DRB CASE ACTION LOG (SITE DEV PLAN - BP)

DRB Application No.: 08DRB-70072

Project # 1006925

Project Name: UNIVERSITY HEIGHTS ADDN

**THE CORNELL HOUSES**  
204 & 6 CORNELL SE, ALBUQUERQUE, NEW MEXICO  
SITE PLAN FOR RELOCATED BUILDINGS  
LOTS 3, 4 & NORTH 6' OF LOT 5, BLOCK 10, UNIVERSITY HEIGHTS

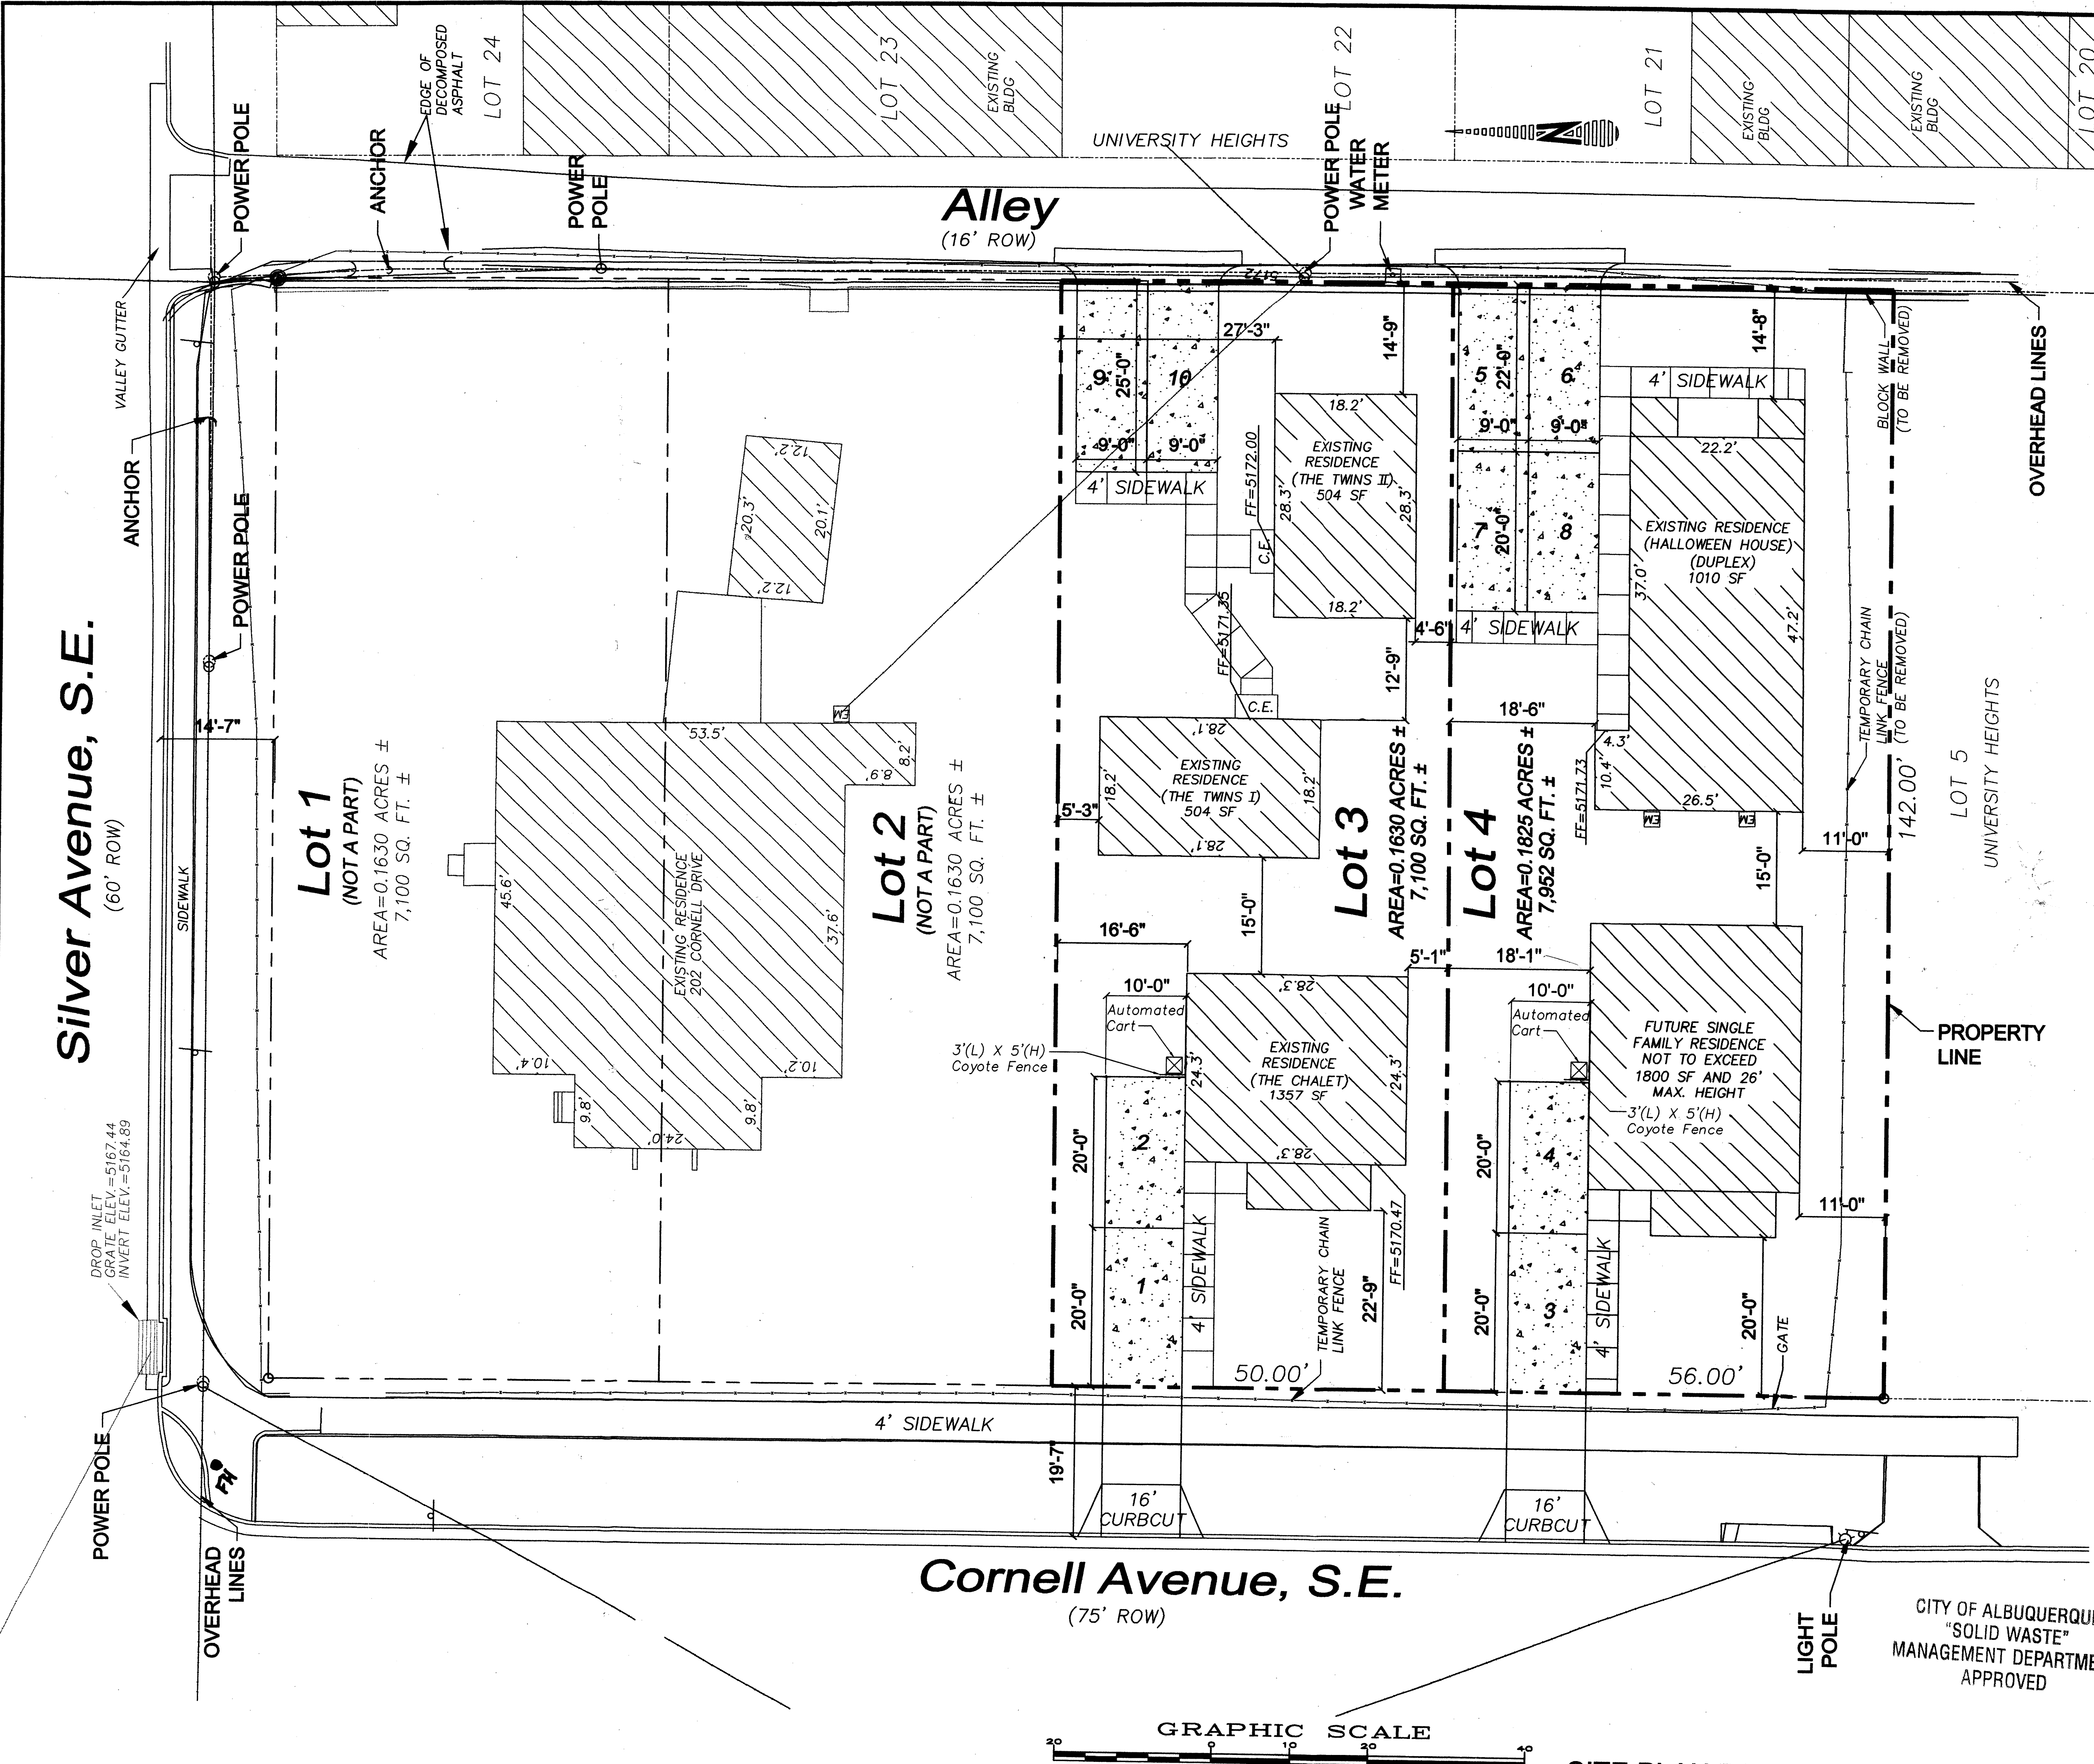
PLANNING (Last to sign): - show cart storage

EPC Condition of Approval No. 6 requires a defined storage area, not visible from street, for duplex refuse carts.
